CITY OF ALBUQUERQUE

PLANNING DEPARTMENT – Development Review Services

RE: **X-Factor, 3023 Montclair NE**
Grading and Drainage Plan
Engineer's Stamp Date (no date, dwg date 2-26-14)(File: G17D089)

|                     | GRADING AND DRAINAGE PLAN                                                       | DATE 2-26-14          |

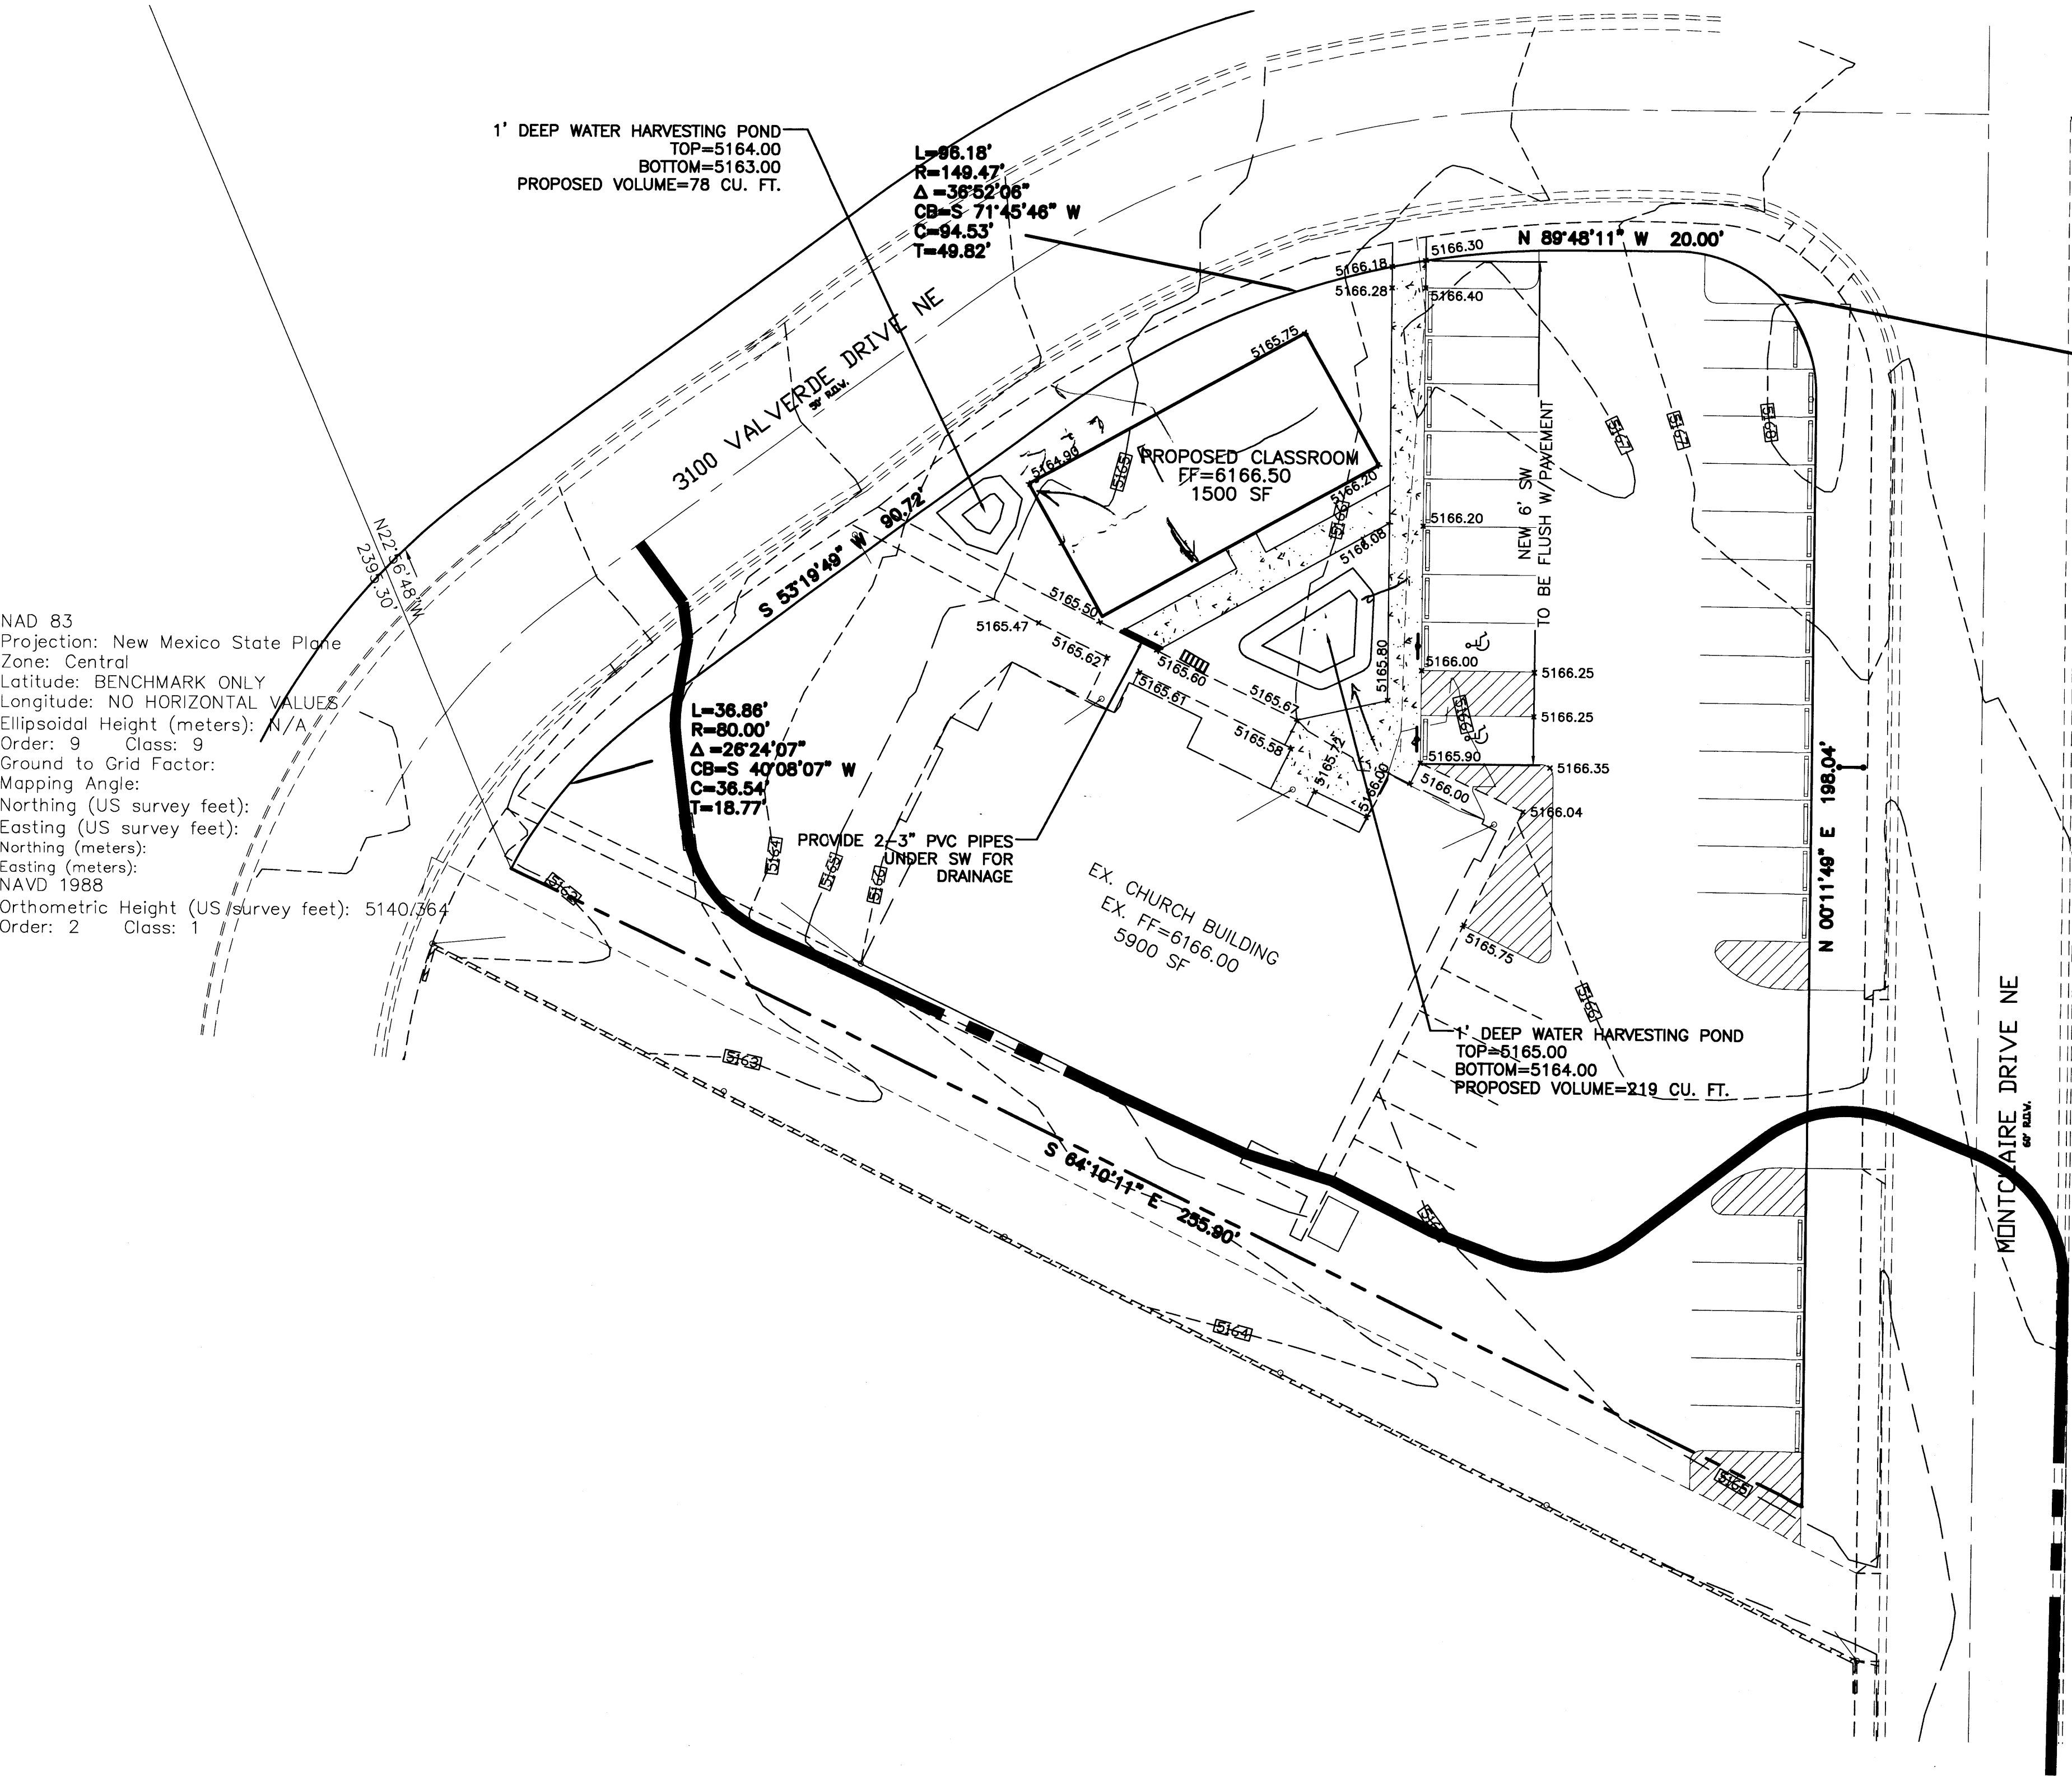
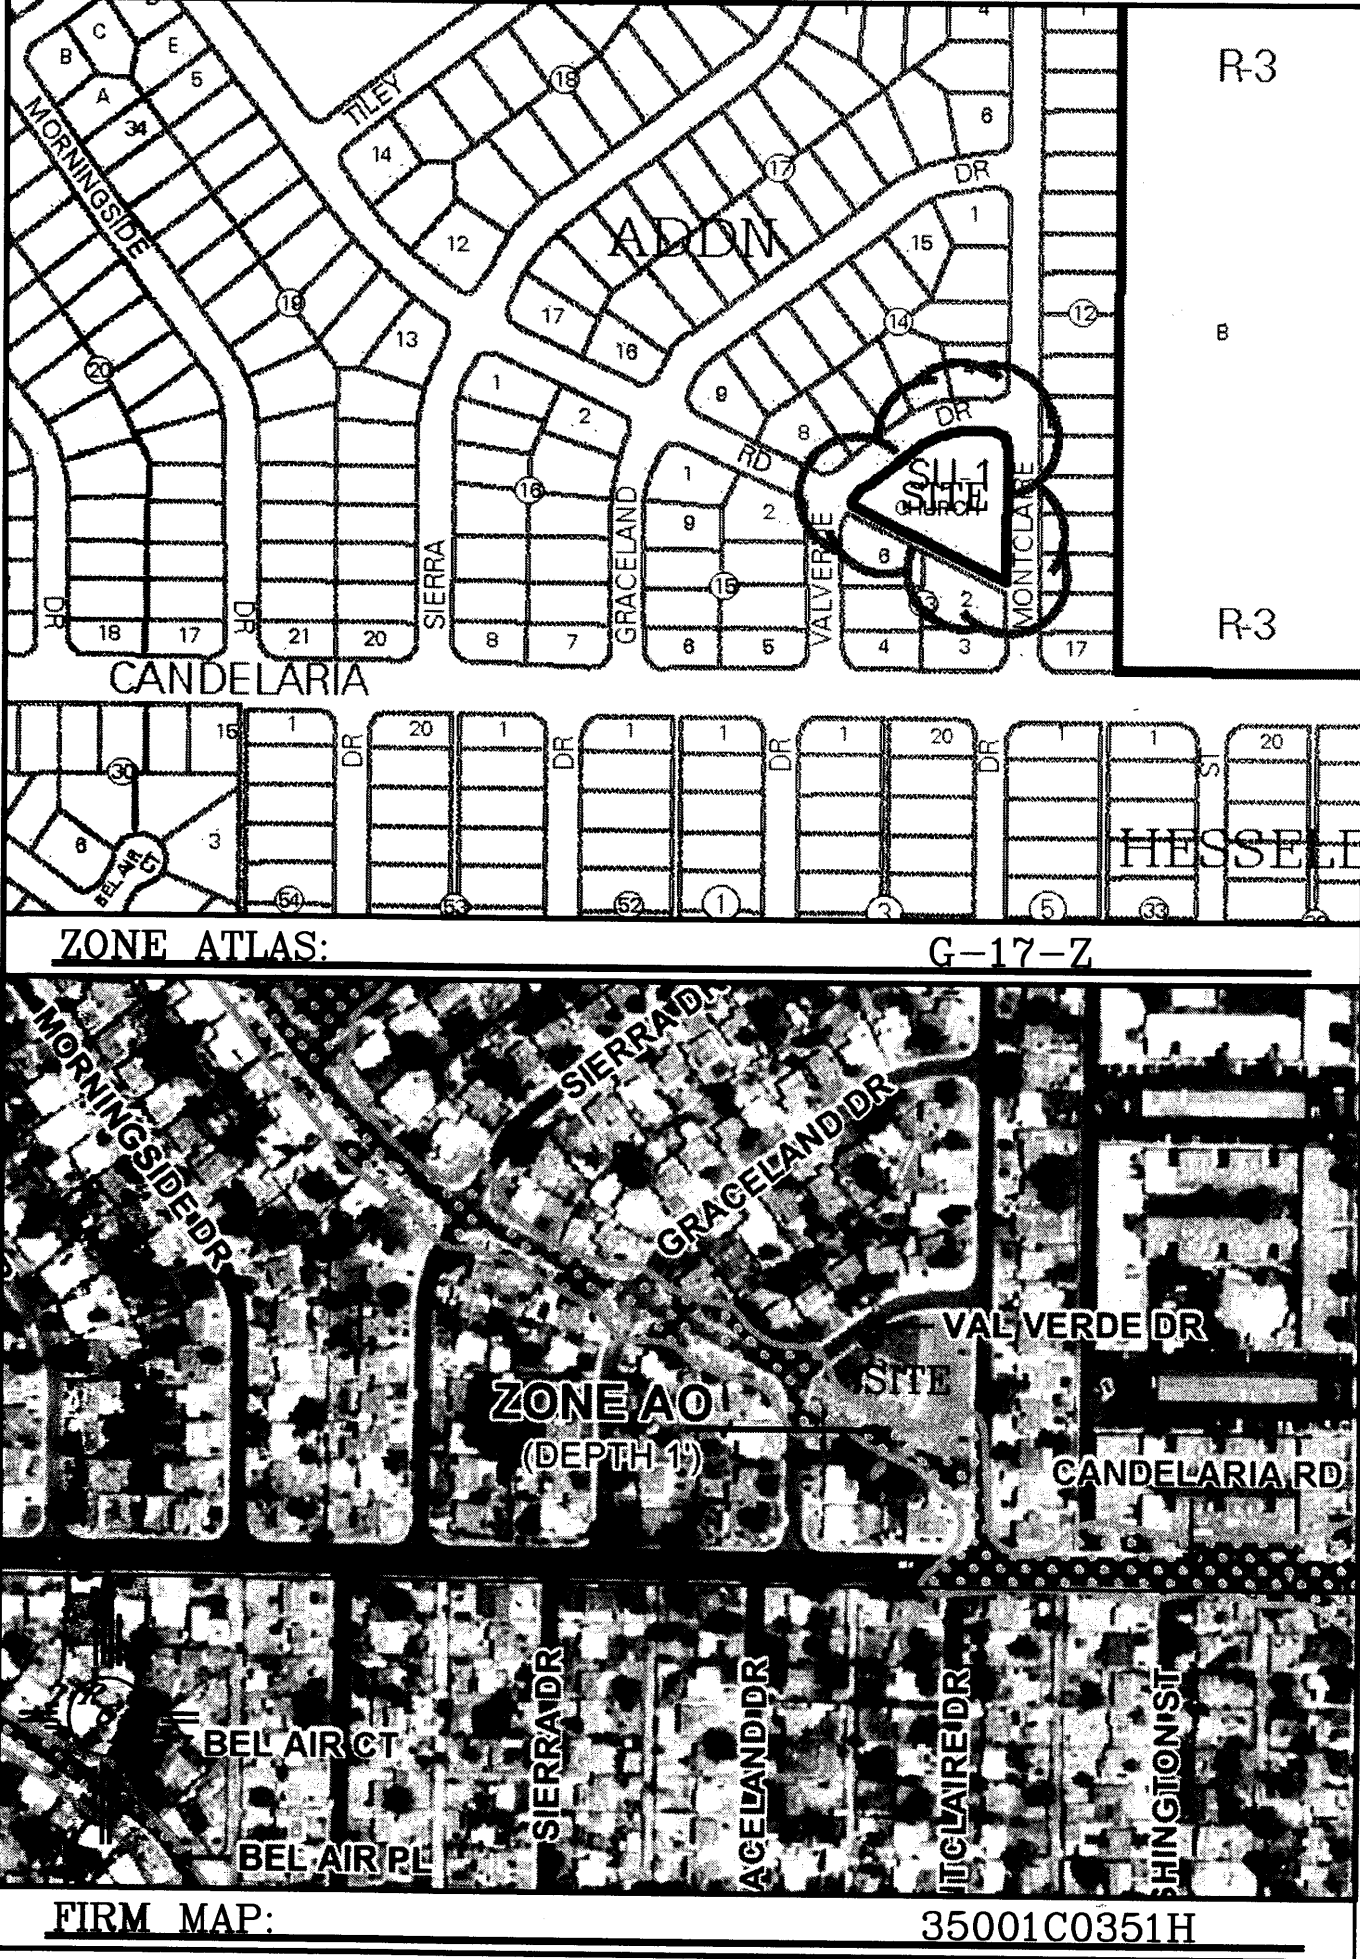
- Prior to Certificate of Occupancy, the As-built Grading and Drainage Plan must show roof and new sidewalks drain into ponds.
